A66 Northern Trans-Pennine Project TR010062

Application for a Non-Material Change to The A66 Northern Trans-Pennine Development Consent Order 2024

Draft Amendment Order

10 December 2025

Drawing Number	Project	Originator	Volume
HE565627	- AMY	- HAC	-
S0102	-DR	-CH	-000002
Location		Type	Role Number

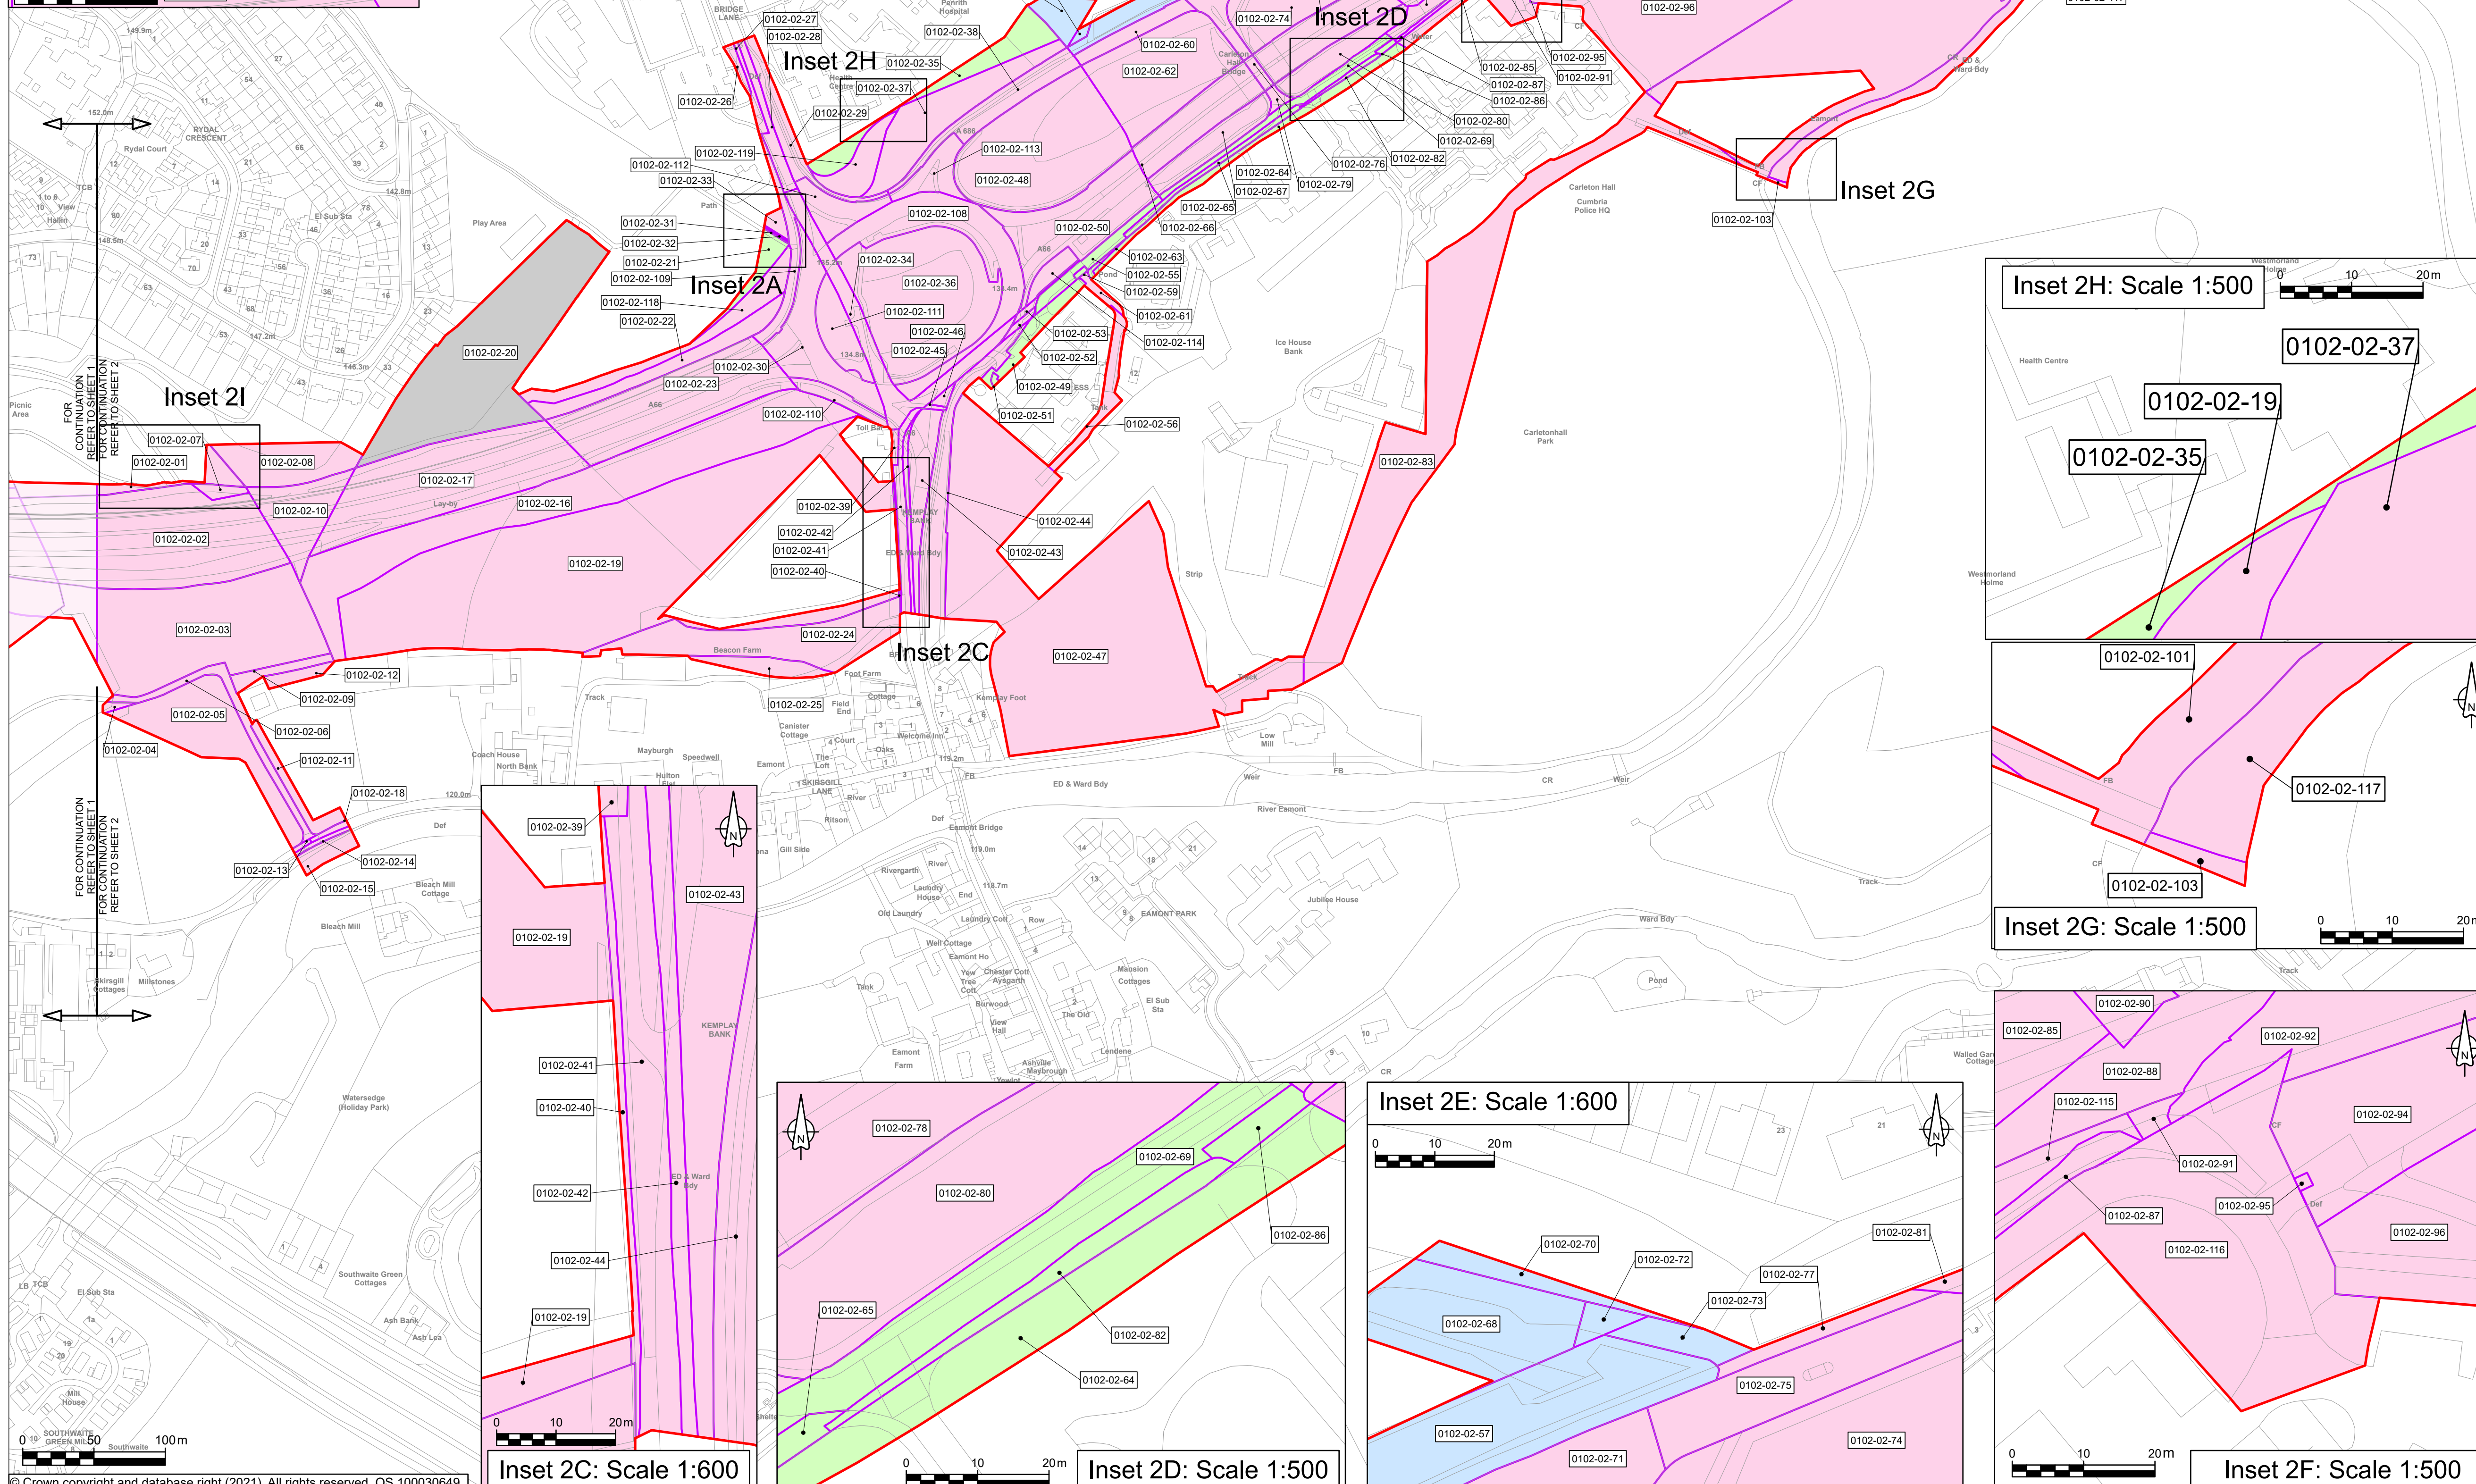
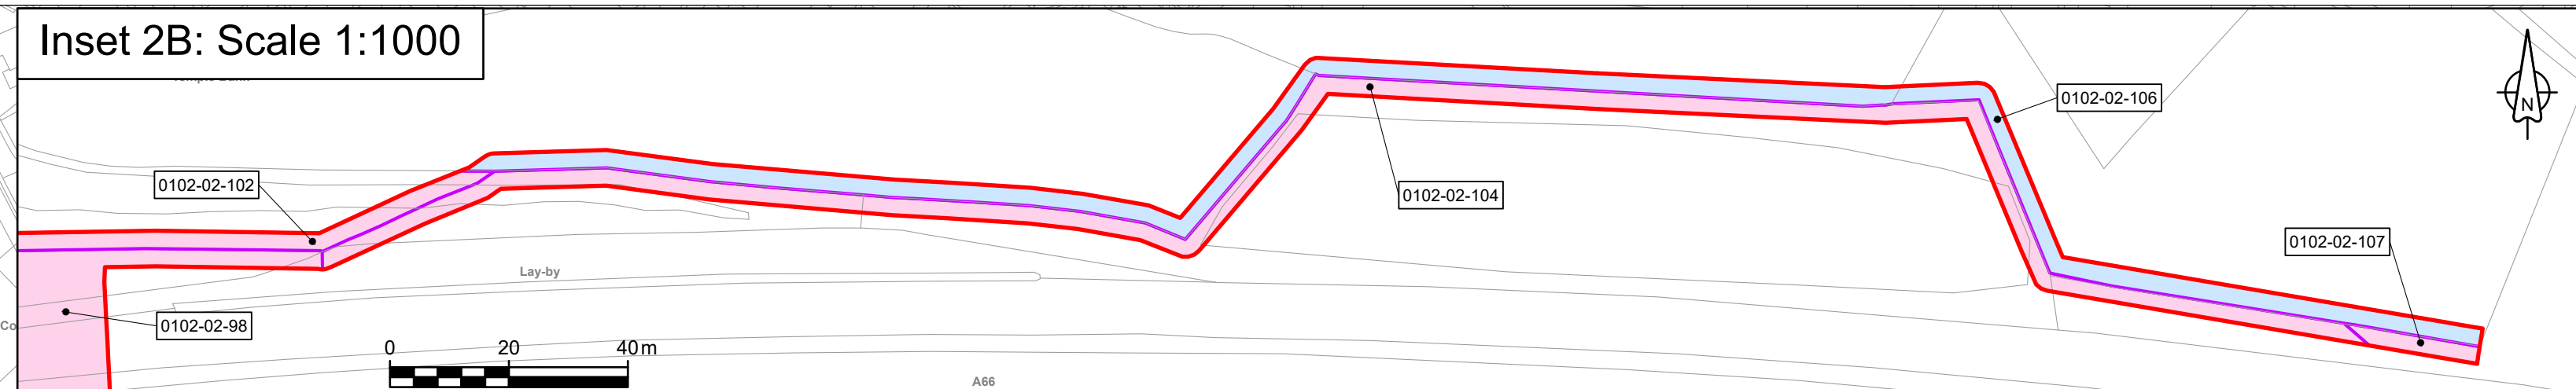
4.—(1) In Part 1 of Schedule 1 (authorised development), following paragraph (d) Work No. 0102-1D, insert a new paragraph (e) as follows—

“(e) **“Work No. 0102-1D-A**— as shown on sheet 2 of the works plans for scheme 0102 and being the construction of additional carriageway and improvements to sections of the existing A66, to include—

(i) the improvement of the existing A66 eastbound and westbound dual carriageway to the east of the new Kemplay Bank Junction; and

(ii) the construction of new private means of access to attenuation pond as shown on sheet 2 of the rights of way and access plans for scheme 0102;”.
